Response to WSCC - Summer Lane, Pagham

1. This note has been prepared by Vectos in response to WSCC's comments on the Transport Statement (TS) in support of the erection of 90 dwellings with associated access and open space at Summer Lane, Pagham (Planning ref: P/58/15/OUT).
2. This note presents WSCC's comments in their entirety before providing a response.

DRAWING NUMBER:	120843/SK/15	REVISION:	A
-----------------	--------------	-----------	---

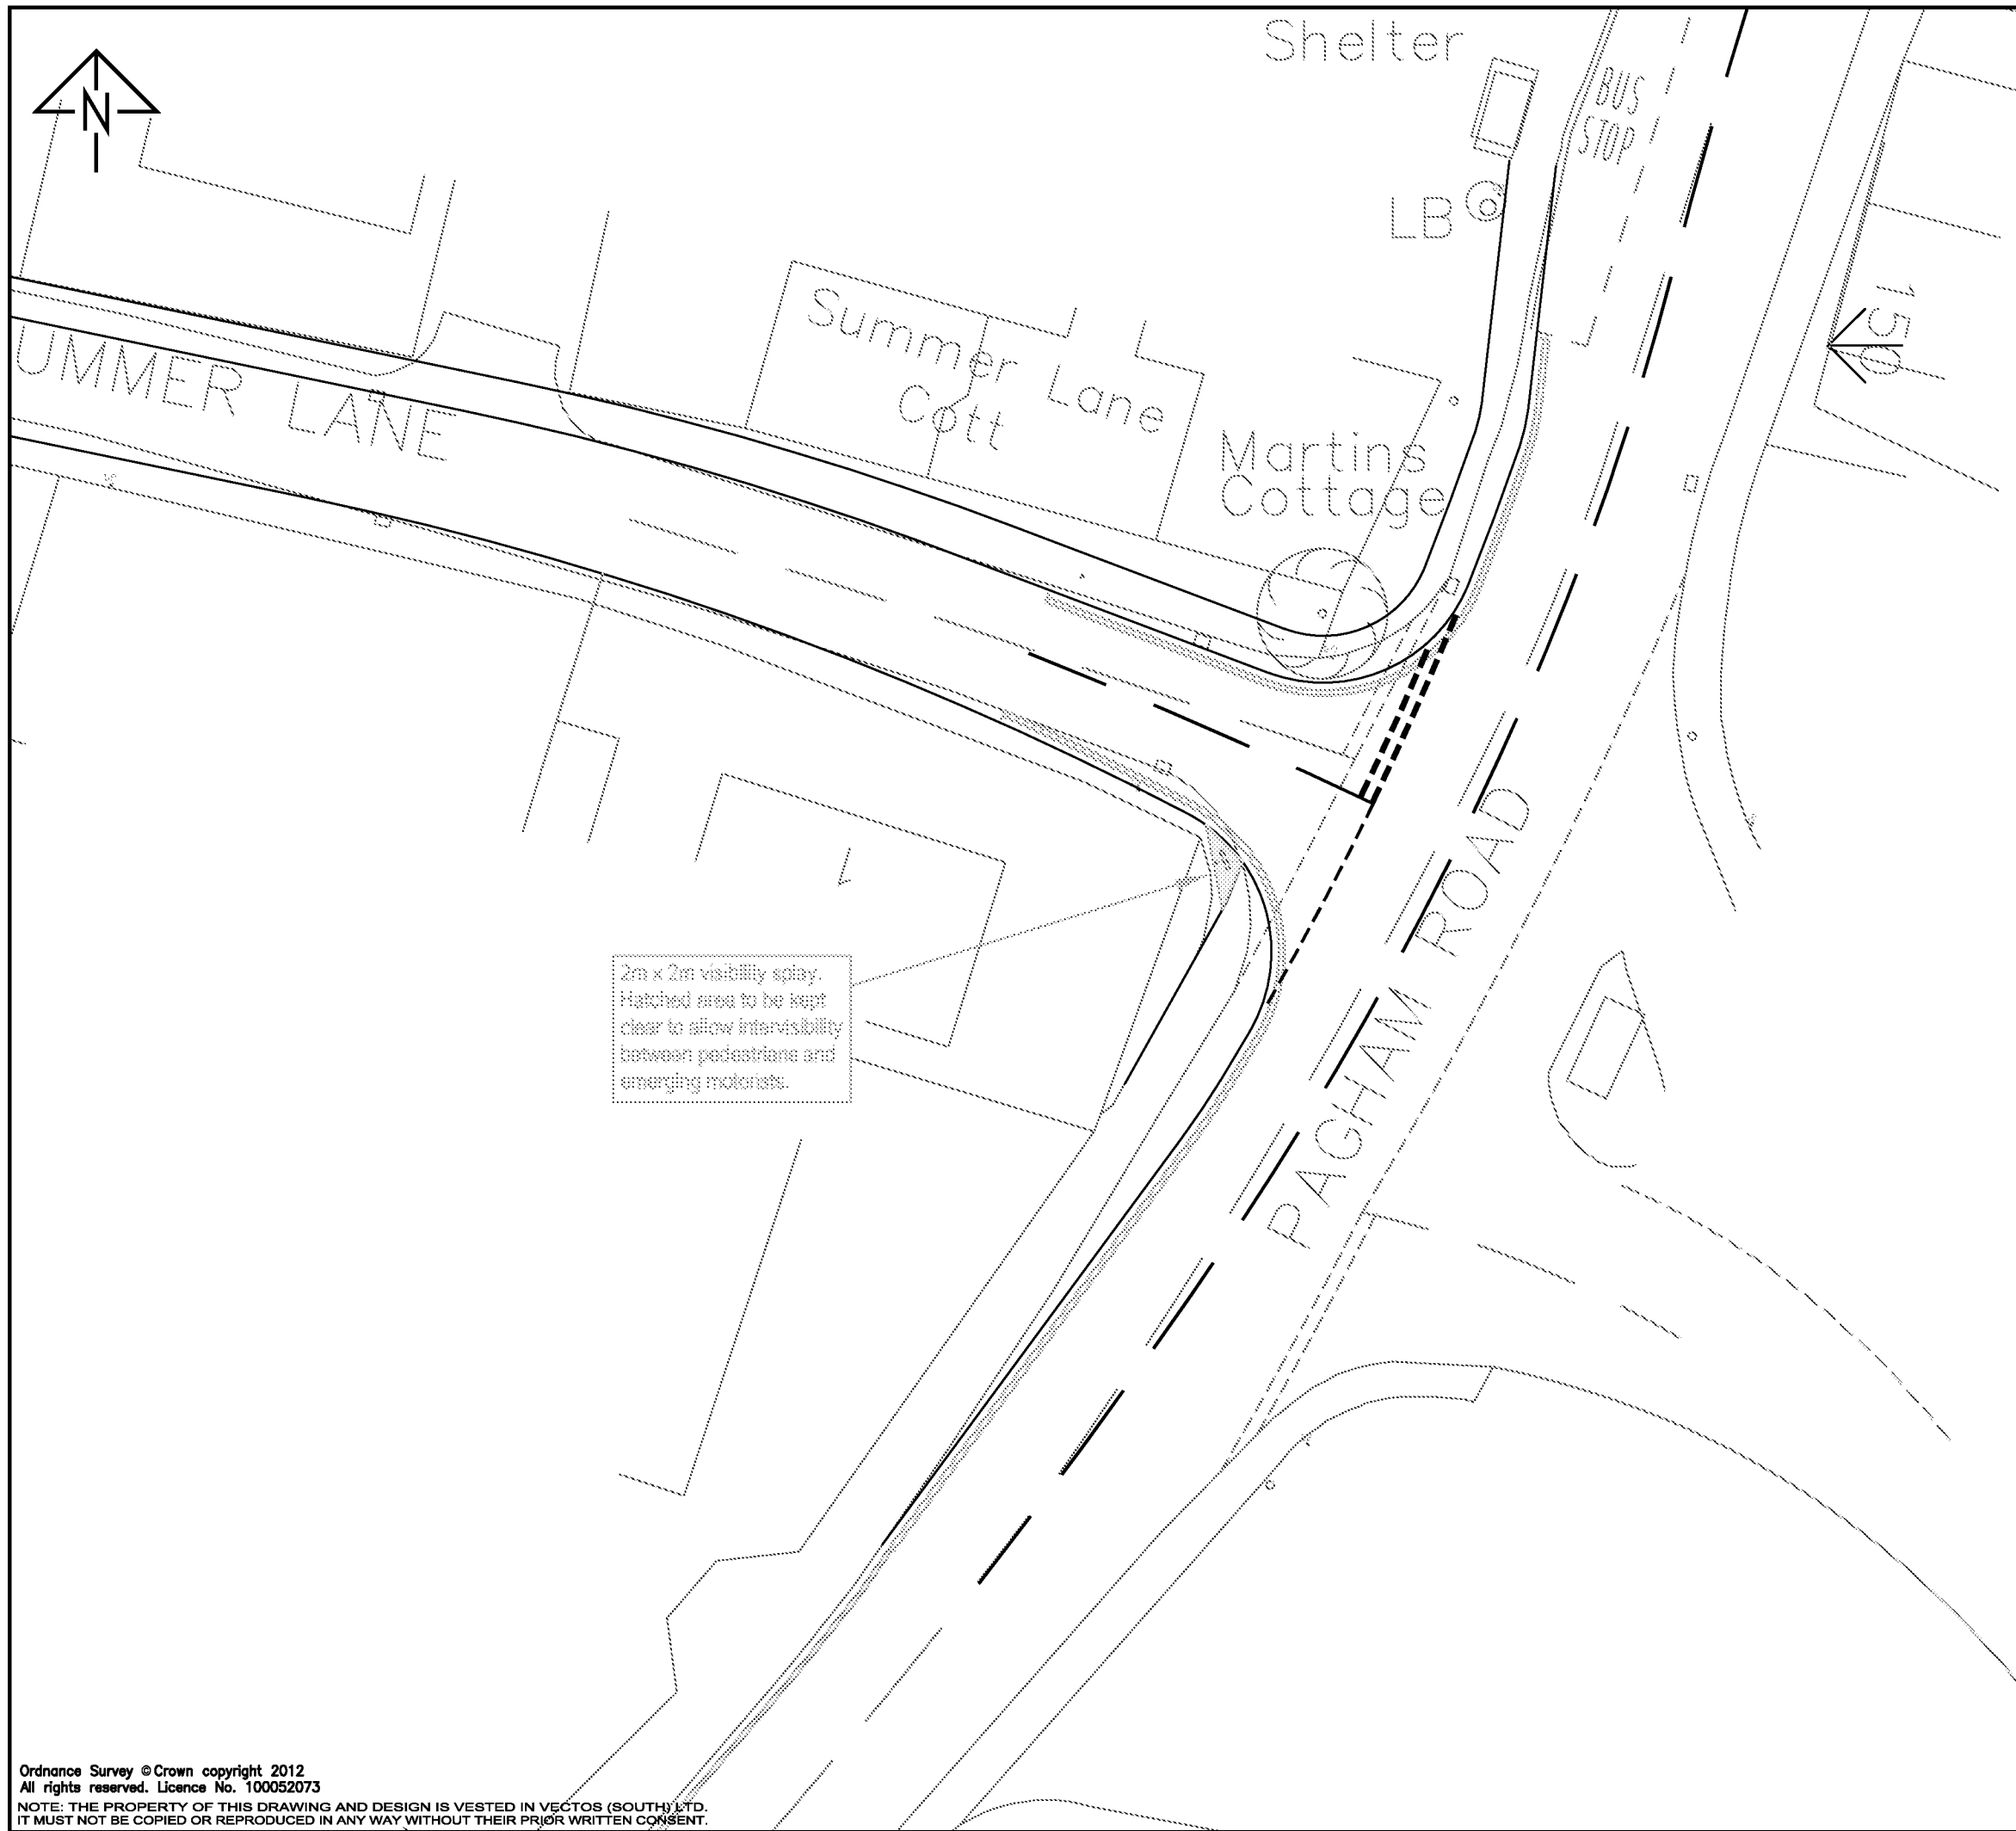
“The second problem is in regards of visibility for northbound pedestrians on Pagham Road at the Summer Lane junction. The realignment of the junction does however reduce intervisibility between pedestrians and those vehicles exiting Summer Lane. It is acknowledged that options are limited given the visibility is primarily restricted by the fence of the adjacent property. In addressing the above problem (clearance to features), there may be the possibility of provide a narrow margin. This in turn may assist in the positioning of pedestrians crossing and visibility to oncoming vehicles. An exception report may need to be prepared by the LHA in respects of this matter if this cannot be addressed.”

13. In order to address the pedestrian intervisibility concerns raised by WSCC above, drawing 120843/SK/15 Rev A has been produced. The footway has been realigned to allow the required visibility.
